Awel y Môr Offshore Wind Farm

Comments on Land Use Consultants' Review of LVIA and SLVIA

Deadline 2

Date: 09 November 2022

Figure: 31j
Viewpoint 4: Moelfre Headland at sculpture
Awel y Môr Offshore Wind Farm
© Crown copyright. All rights reserved (2021). Licence number 0100031673

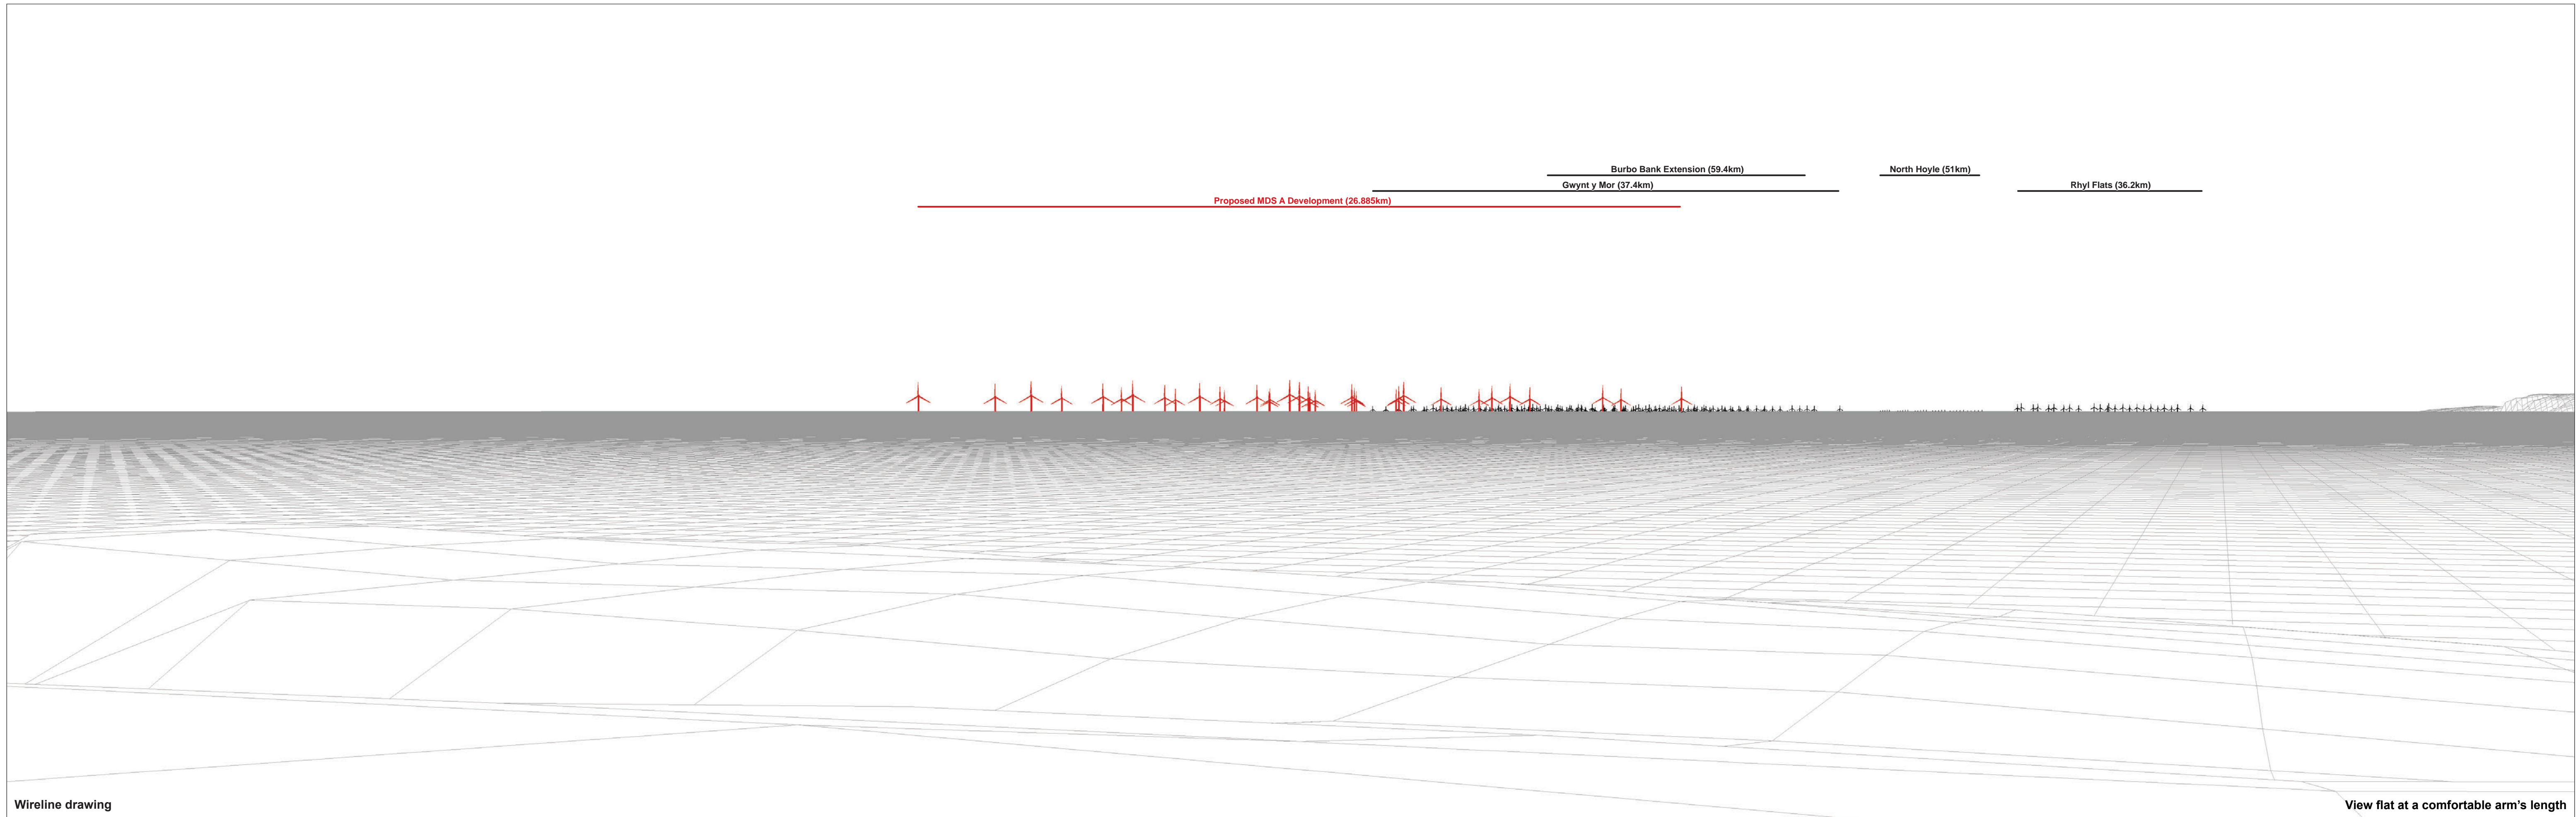
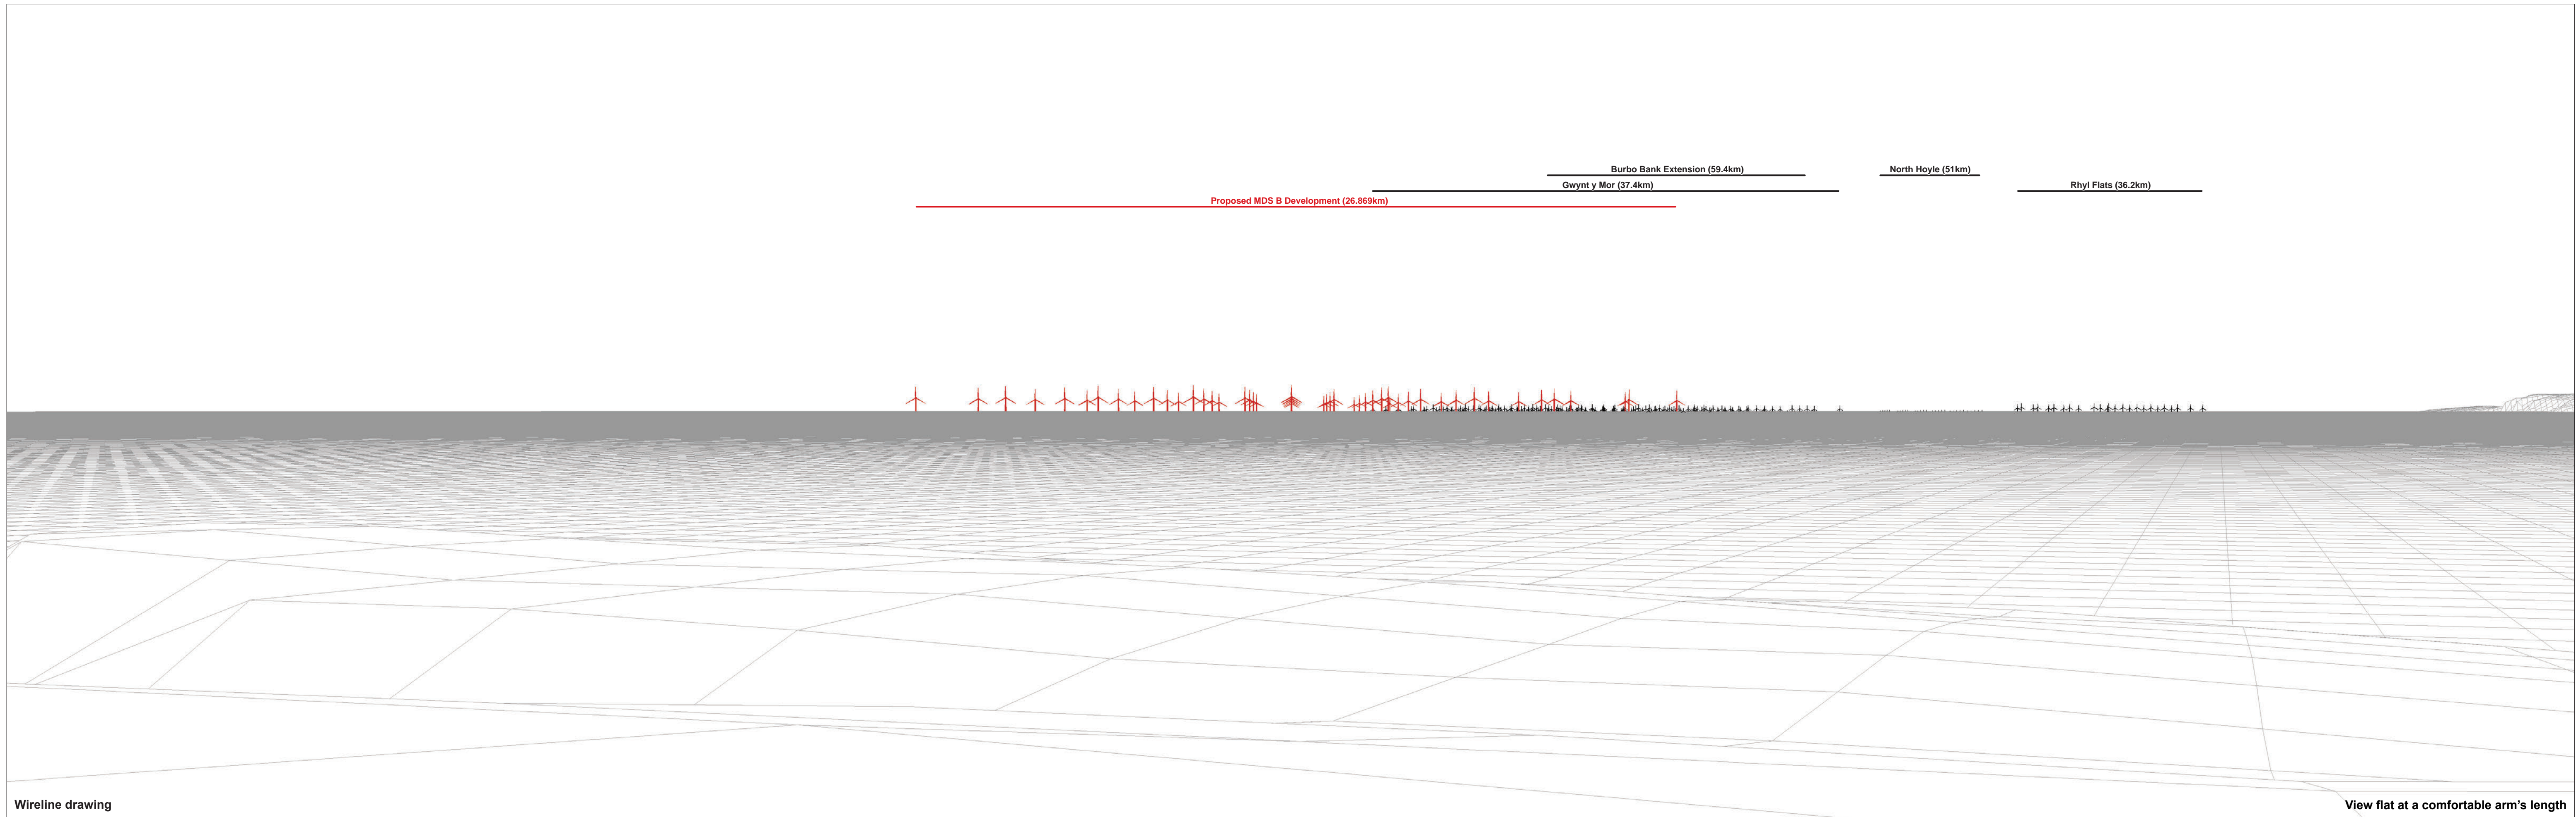
VP 4. Moelfre Headland at sculpture (daytime)	Significant	Agreed	Moderate (significant)	Agreed	Agreed	Agreement noted.
VP 5. Red Wharf Bay	Significant	Agreed	Moderate (significant)	Agreed	Agreed	Agreement noted.

Viewpoint 4. Moelfre Headland at sculpture (night-time)	Significant	Agreed	Minor (non-significant)	Agreed. At PEIR the magnitude of change for 2000 candela lights was medium-low. This has reduced to negligible for 200 candela lights.	Agreed at REP1-080-Annex B - 6.1.33	Agreement noted
Across Isle of Anglesey, with reference to:	Locally significant, but	Agreed: the SLVIA assesses significant night-time effects "in	Moderate-minor (non-significant) in the vicinity of	Agreed for the 200 candela scenario.	REP1-080-Annex B - 6.1.33	Agreement noted

FIGURE TITLE:
Viewpoint 37 - Cefn Coch Stone Circle

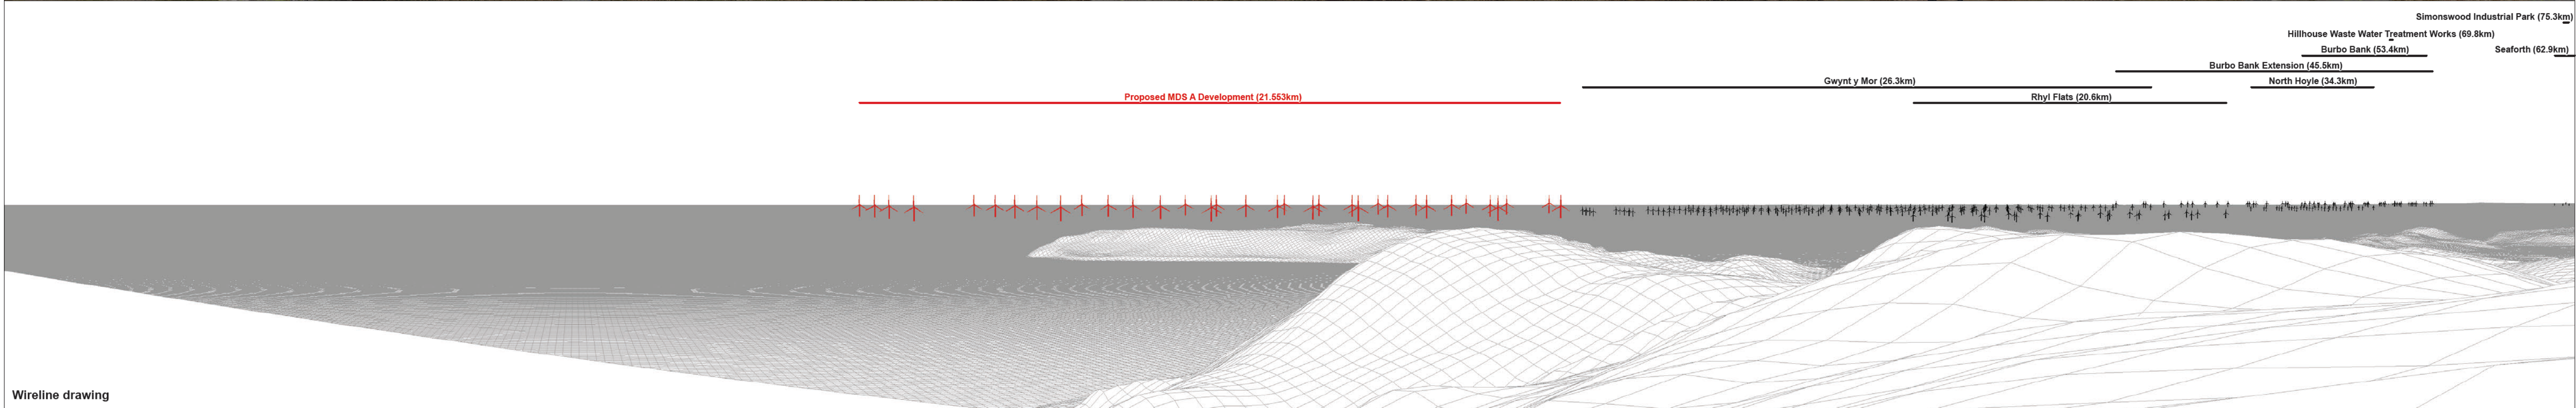
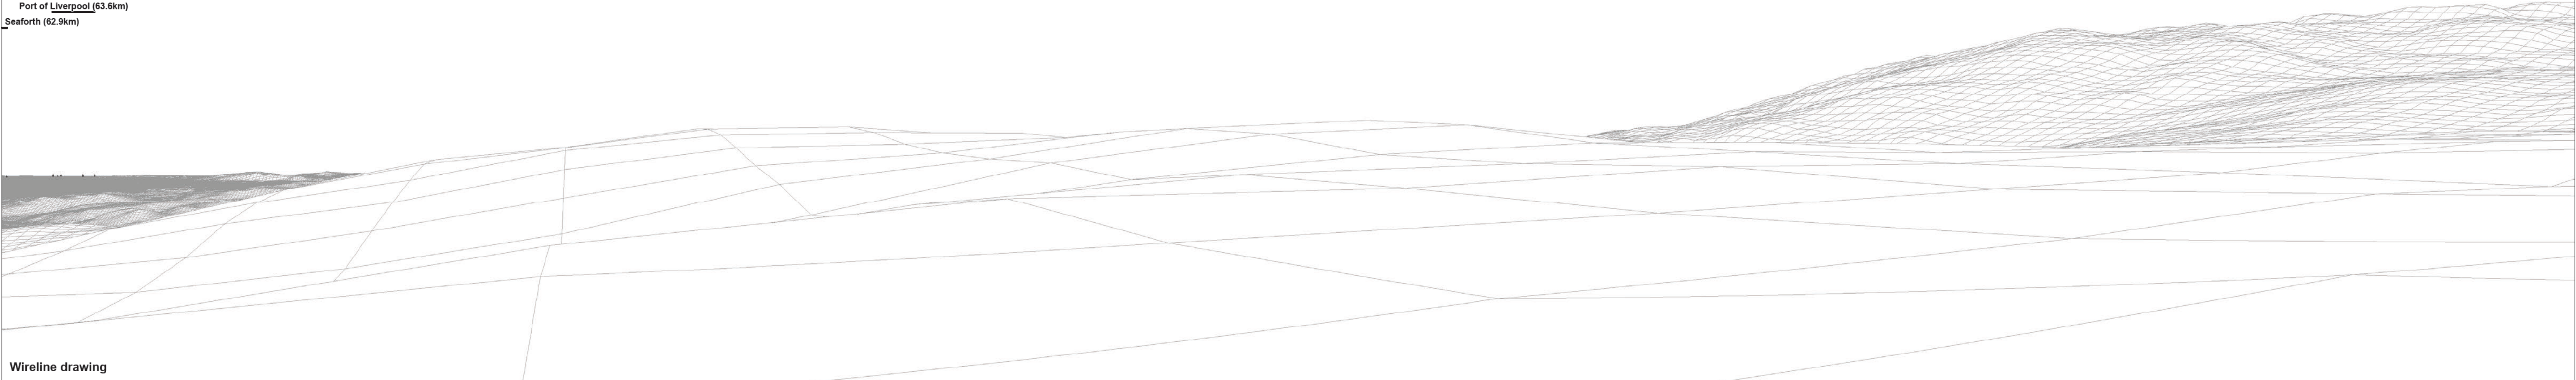
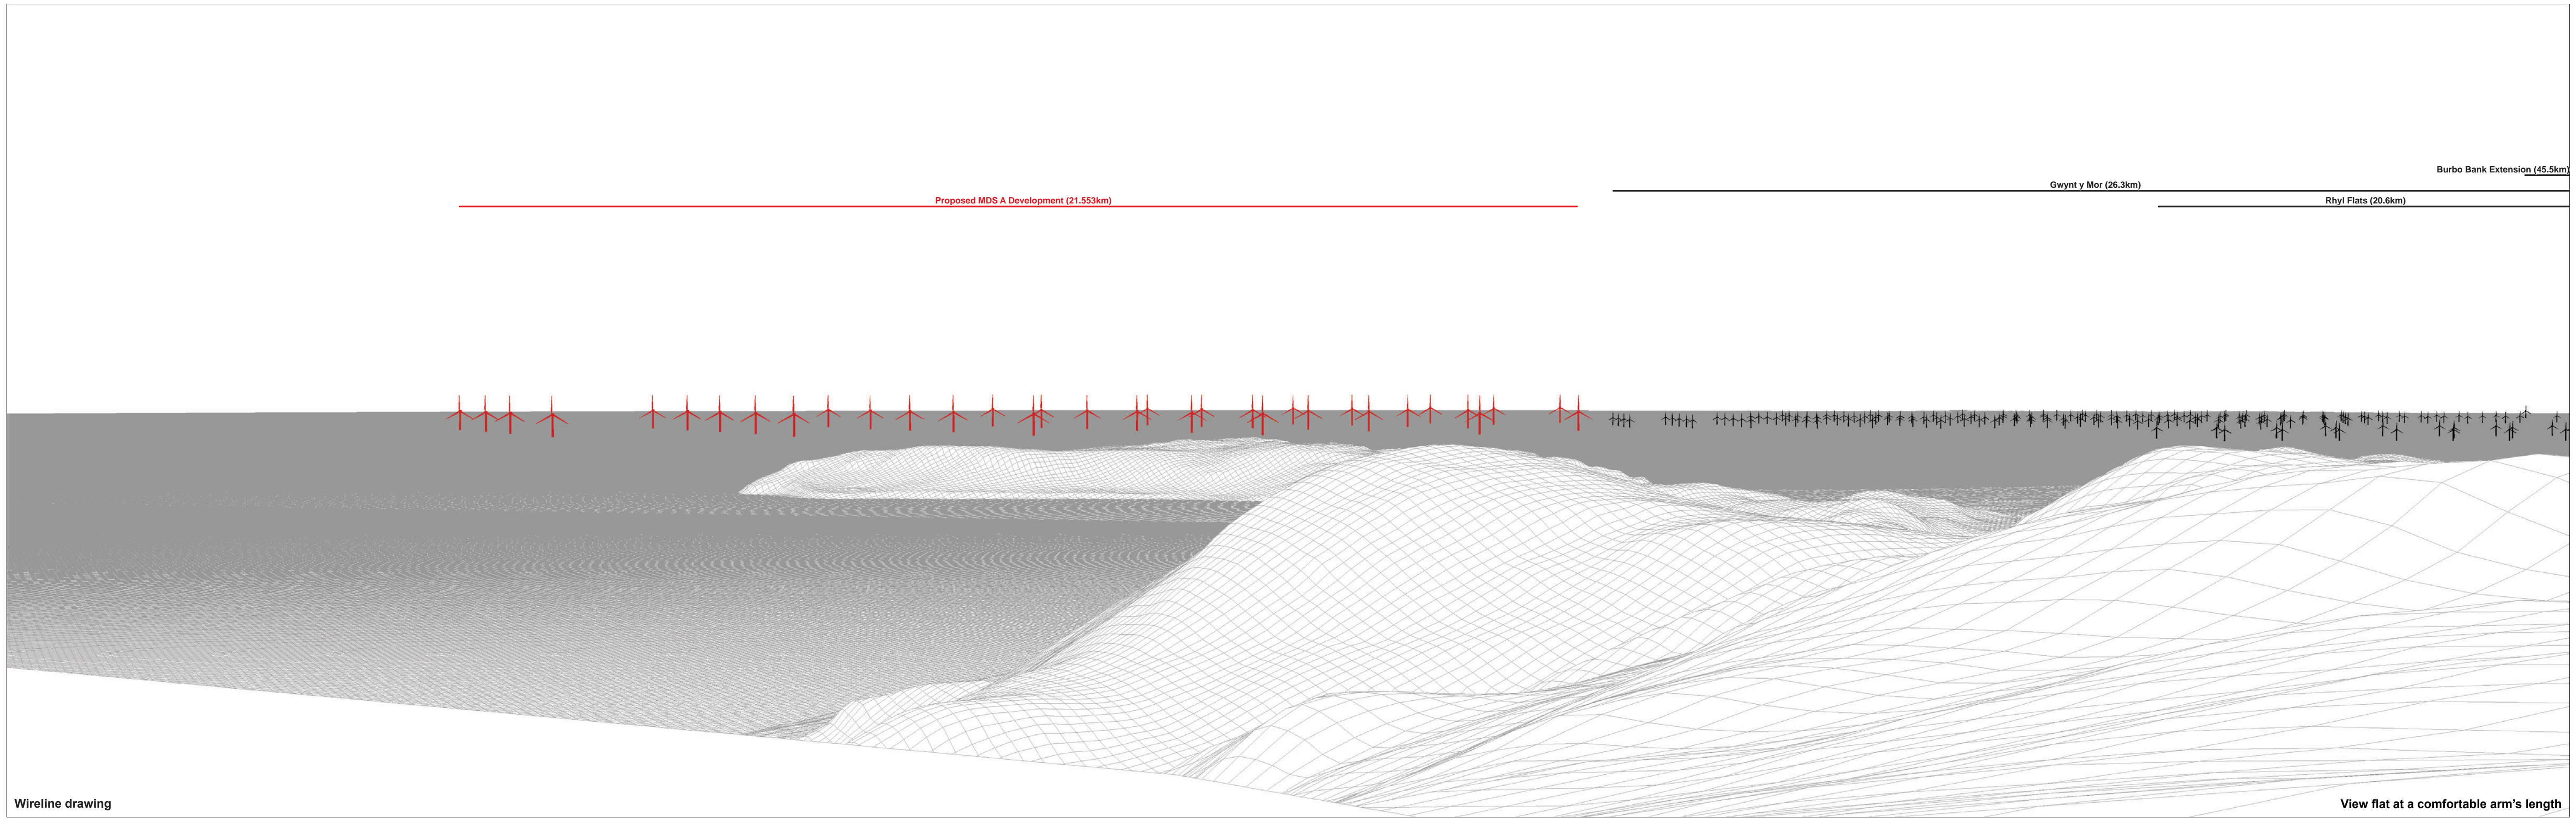
VP 29. Colwyn Bay Promenade	Significant	Agreed	Moderate-major (significant)	Agreed	No comment received	Agreement noted
VP 37. Cefn Coch Stone Circle	Significant	Agreed	Moderate (significant)	Agreed	No comment received	Agreement noted
VP 59. Llandudno Promenade – Lifeboat Slipway	Significant	Agreed	Moderate (significant)	Agreed	No comment received	Agreement noted
Llanfairfechan	Locally significant, but otherwise non-significant	Agreed	Moderate (significant) for “seaside properties” and	Agreed (noting comments elsewhere about the scope of effects on settlements)	No comment received	Agreement noted
